From: Amanda Scholes on behalf of Planning.Responses
Sent: 08 June 2020 11:50
To: Planning Scanning
Subject: FW: 2020-05-15-19163-PARCELS A2 & B6, Littlehampton - Drainage Drawings

Comments;

Subject: 2020-05-15-19163-PARCELS A2 & B6, Littlehampton - Drainage Drawings

Type B Manhole

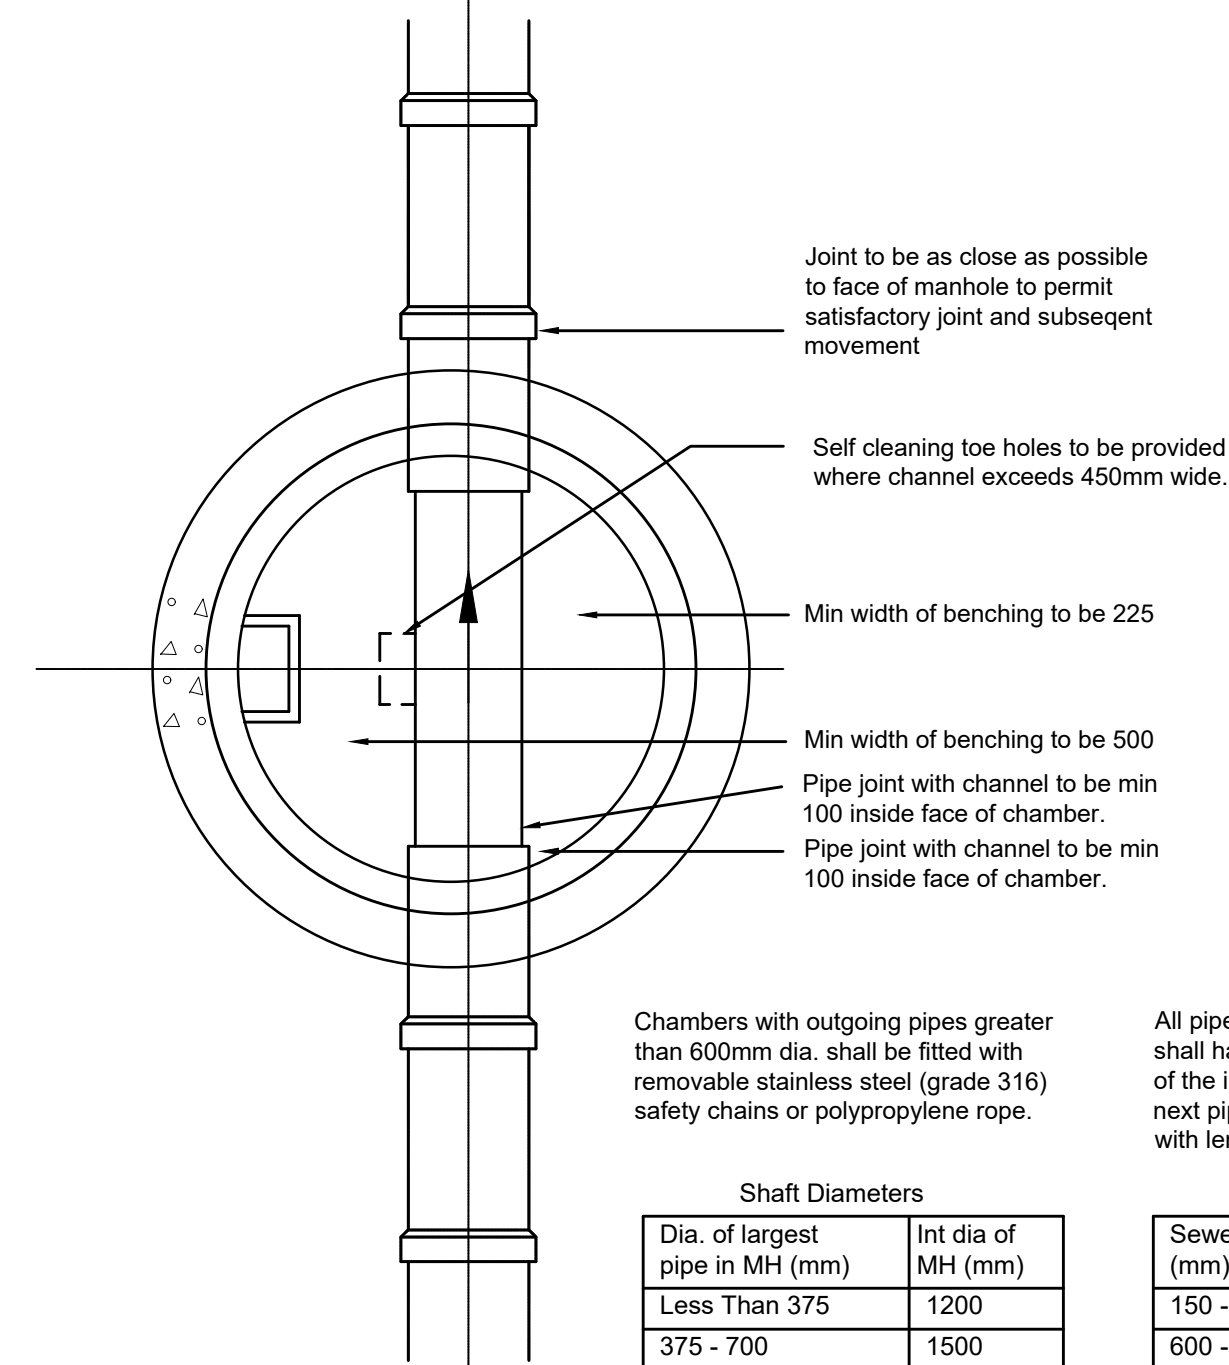
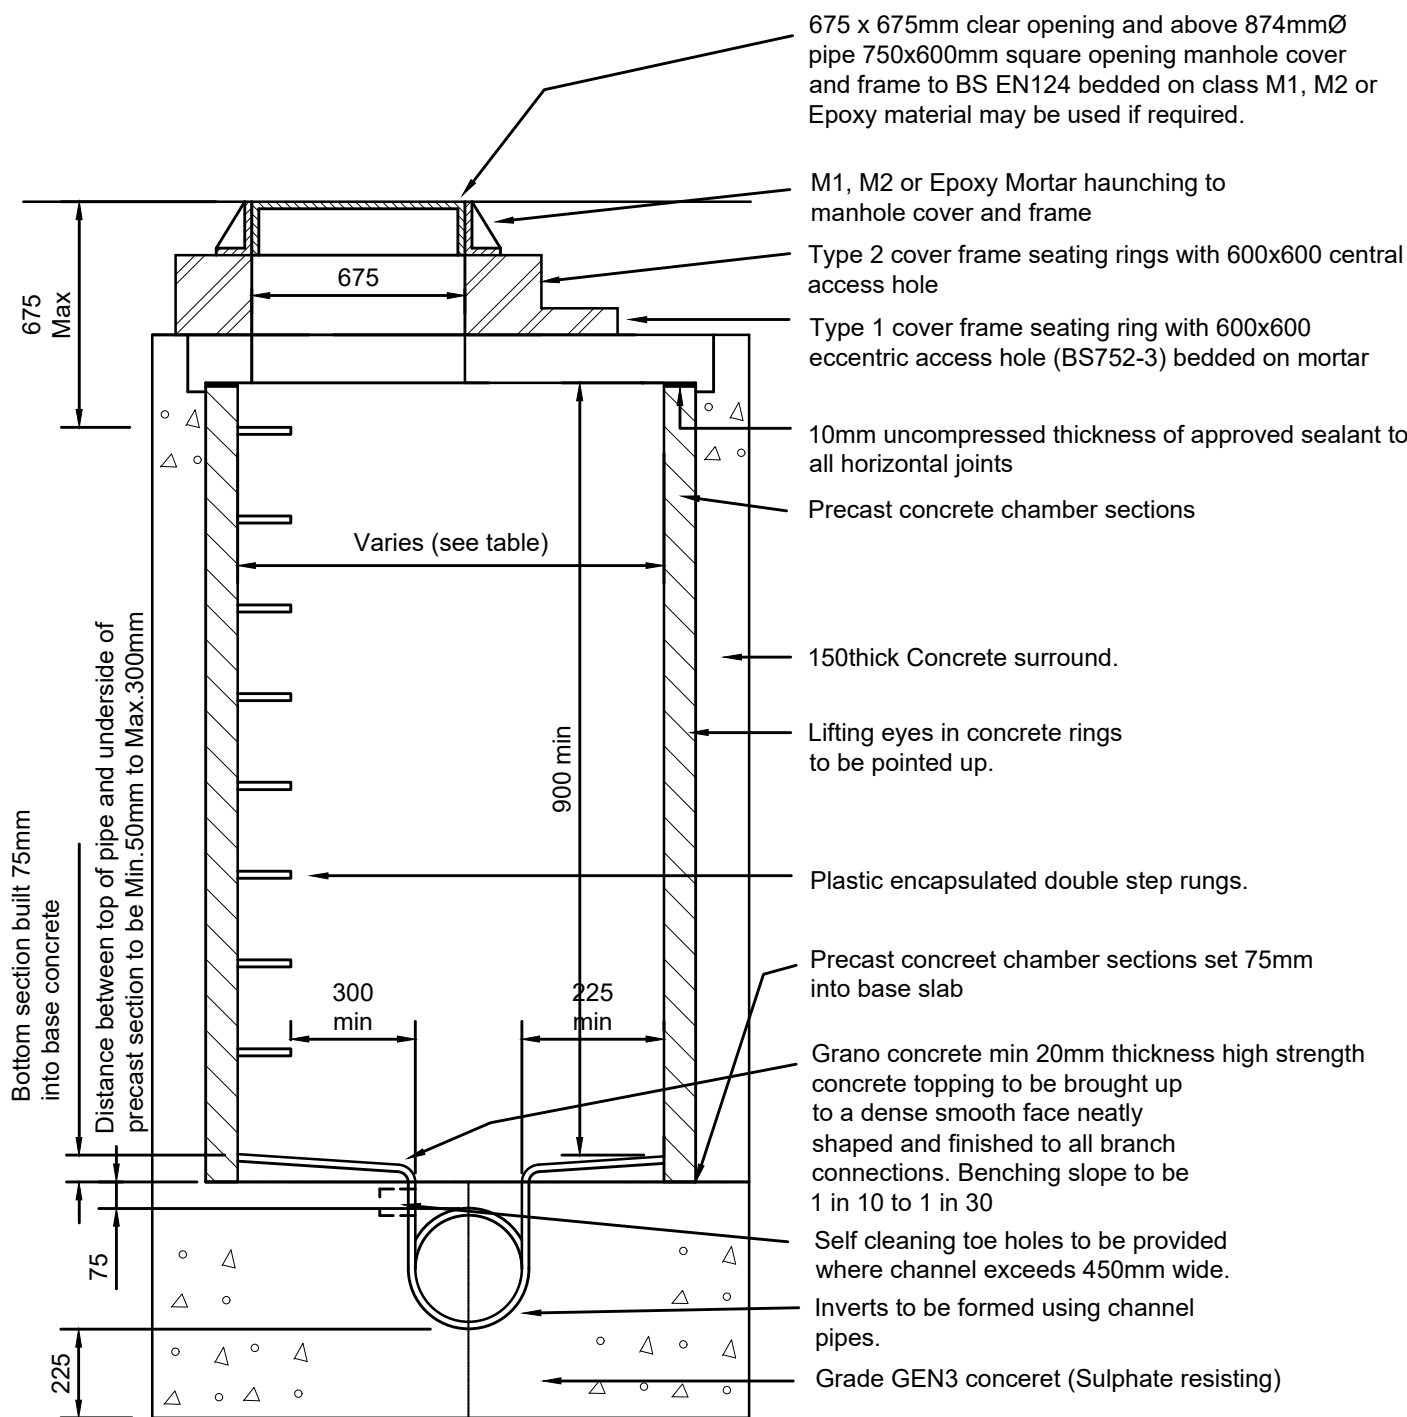
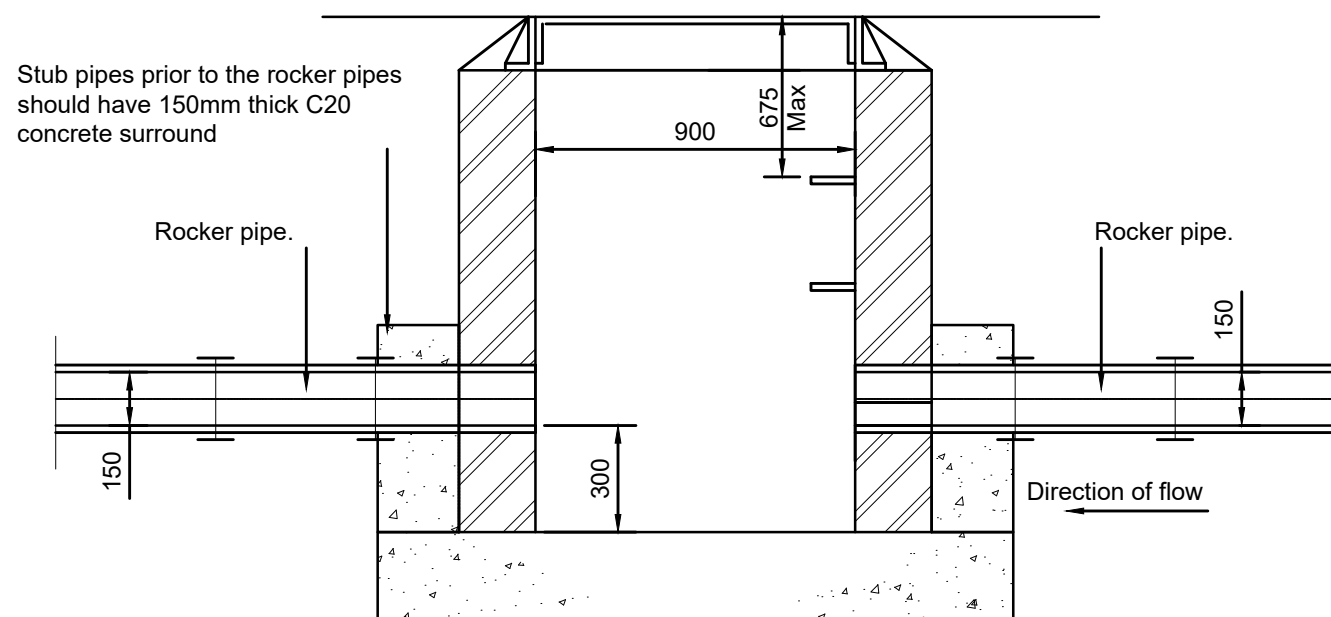
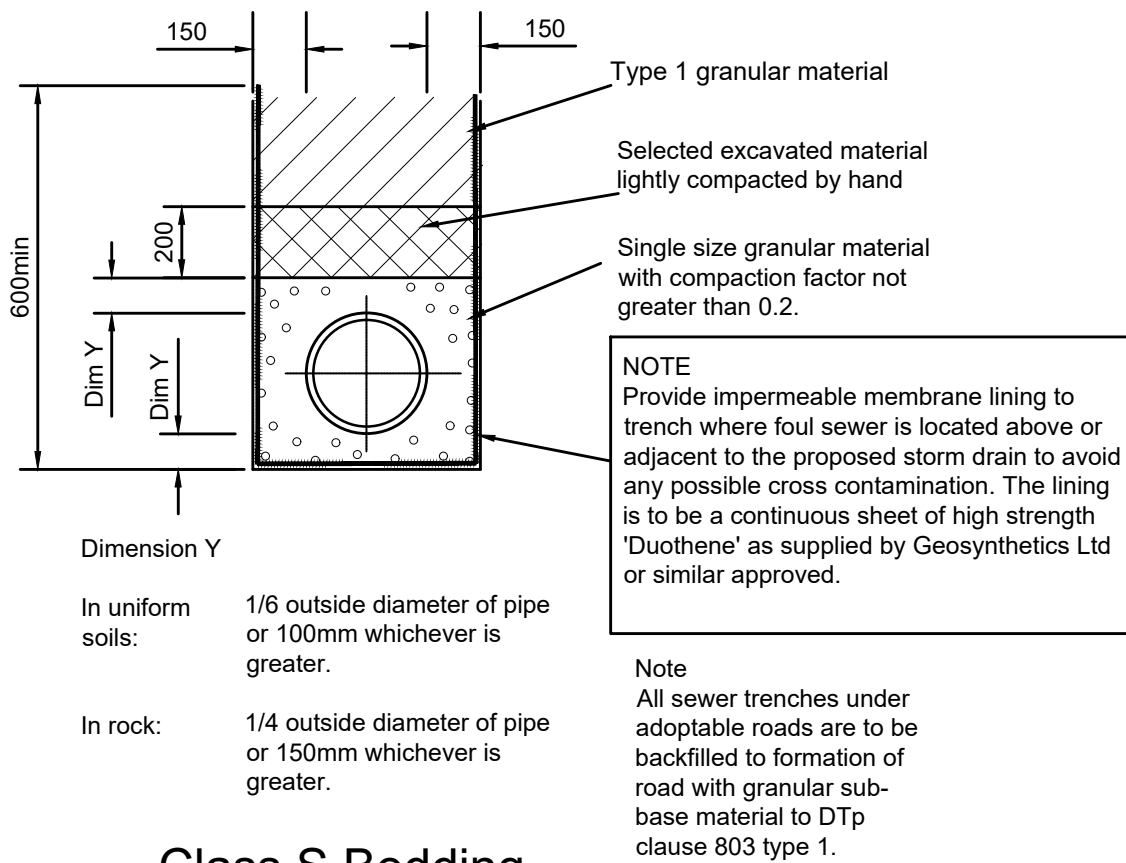
1. CP1 and CP2 (catchpits) on the manhole schedule drawing need to refer to a catchpit detail, not a type B manhole. *ok*
2. Provide non adoptable manhole construction details. *ok*
